From: Laura Gibbons <laura.gibbons@arun.gov.uk>
Sent: 24 November 2020 14:52
To: Planning.Responses <Planning.Responses@arun.gov.uk>
Cc: Simon Davis <Simon.Davis@arun.gov.uk>
Subject: AW/319/20/DOC- The Former Ship Inn Aldwick Street

Engineers Comments Regarding Condition 2- future access and maintenance of watercourse

Client
Surplus Property Investments
Project
The Former Ship Inn, Aldwick Street, Bognor Regis. PO21 3AP
Title
Site Location and Block Plan

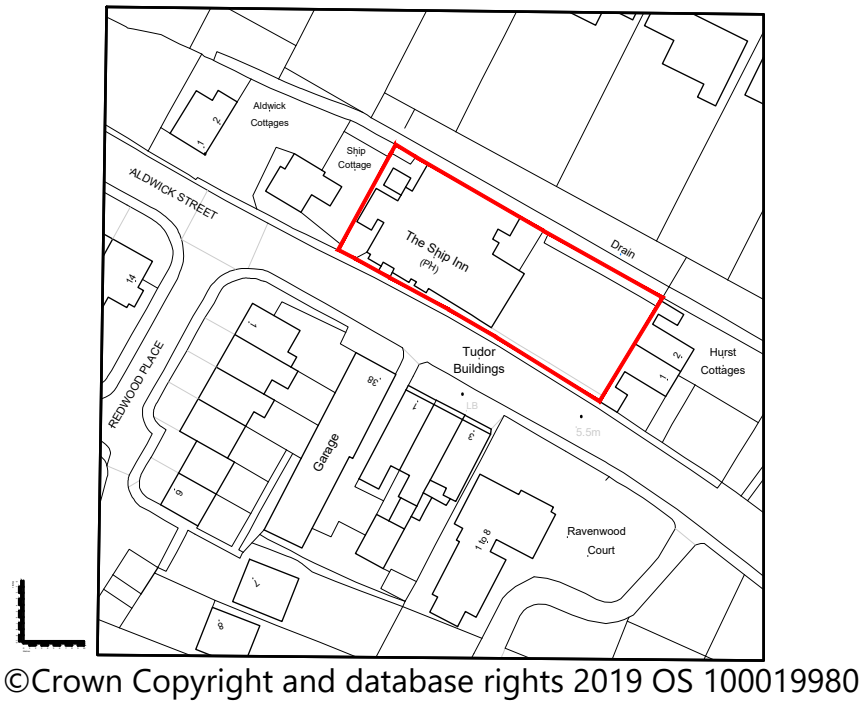
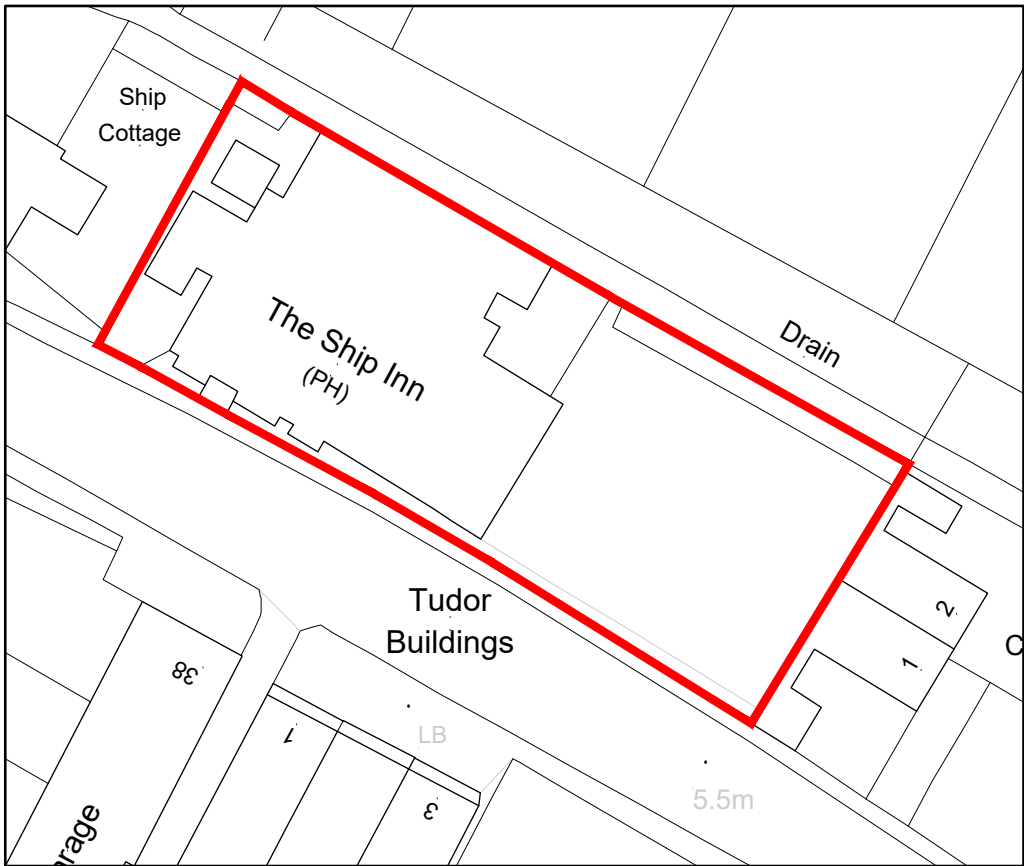
Please can a plan showing the location of the proposed fence relative to top of bank of watercourse be supplied, what distance is being provided between the top of bank and the fence line?

MULTIPLUS™

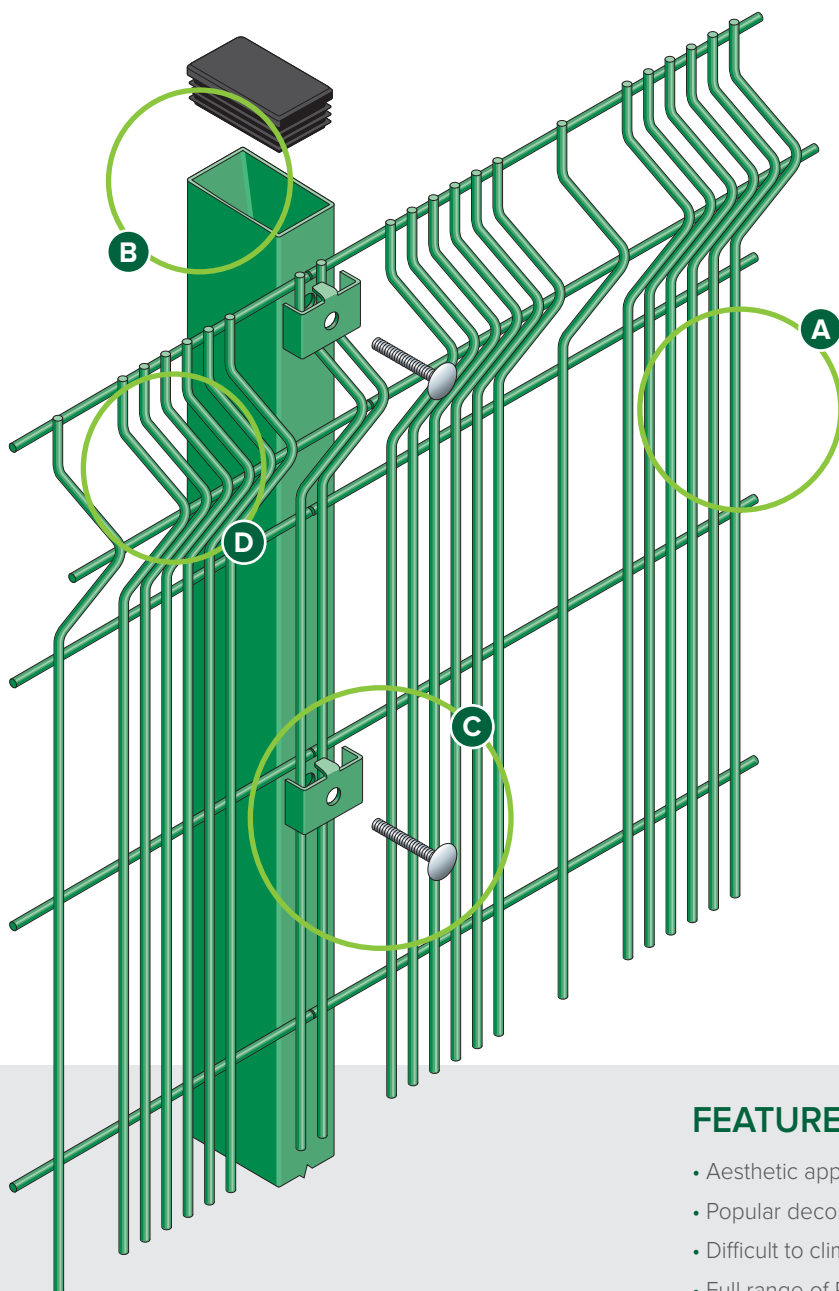
A 900mm access gate is suitable for pedestrian access. However, maintenance will likely require mechanical plant access. We therefore request that in addition a demountable fence is specified to permit access of mechanical plant as and when required.
